Our Ref: EP/40/21/NMA

**Section 96A of the Town & Country Planning Act 1990 (as amended)
Town and Country Planning (Development Management Procedure) (England) Order 2015 (as amended) - Article 10**

Non-material amendment following grant of EP/14/21/HH to add 2 No. small gable dormers to the south elevation.

38 The Roystons East Preston BN16 2TS

Drawing
Proposed Elevations

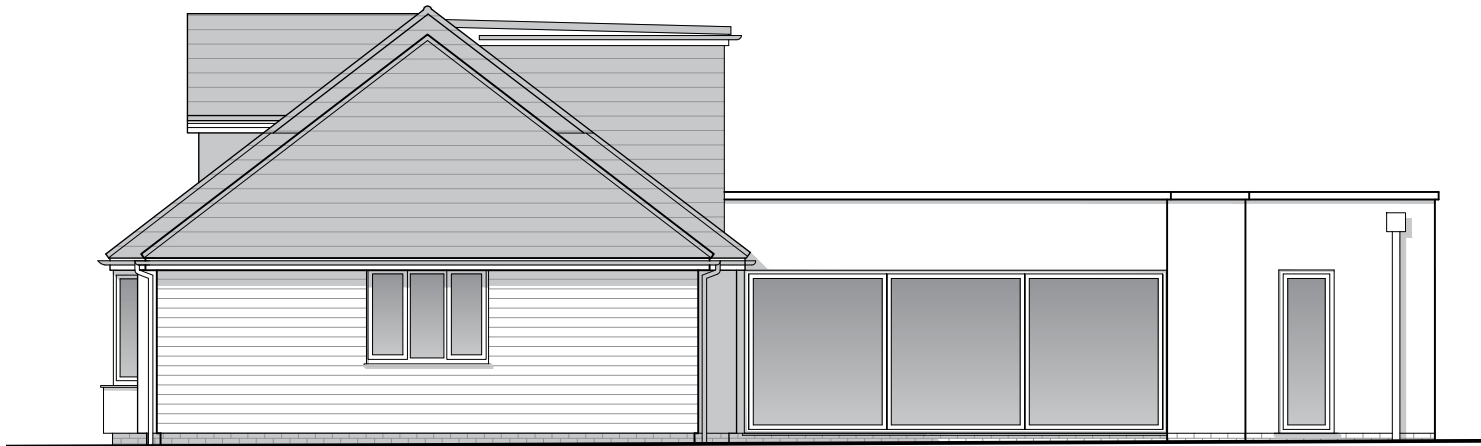
The reasons that these proposals have not been accepted as Non-Material Amendments is because they result in material changes to the appearance of the property and it cannot therefore be considered under section 96A of the Town and Country Planning Act 1990.

These alterations will require submission of a revised planning application for consideration.
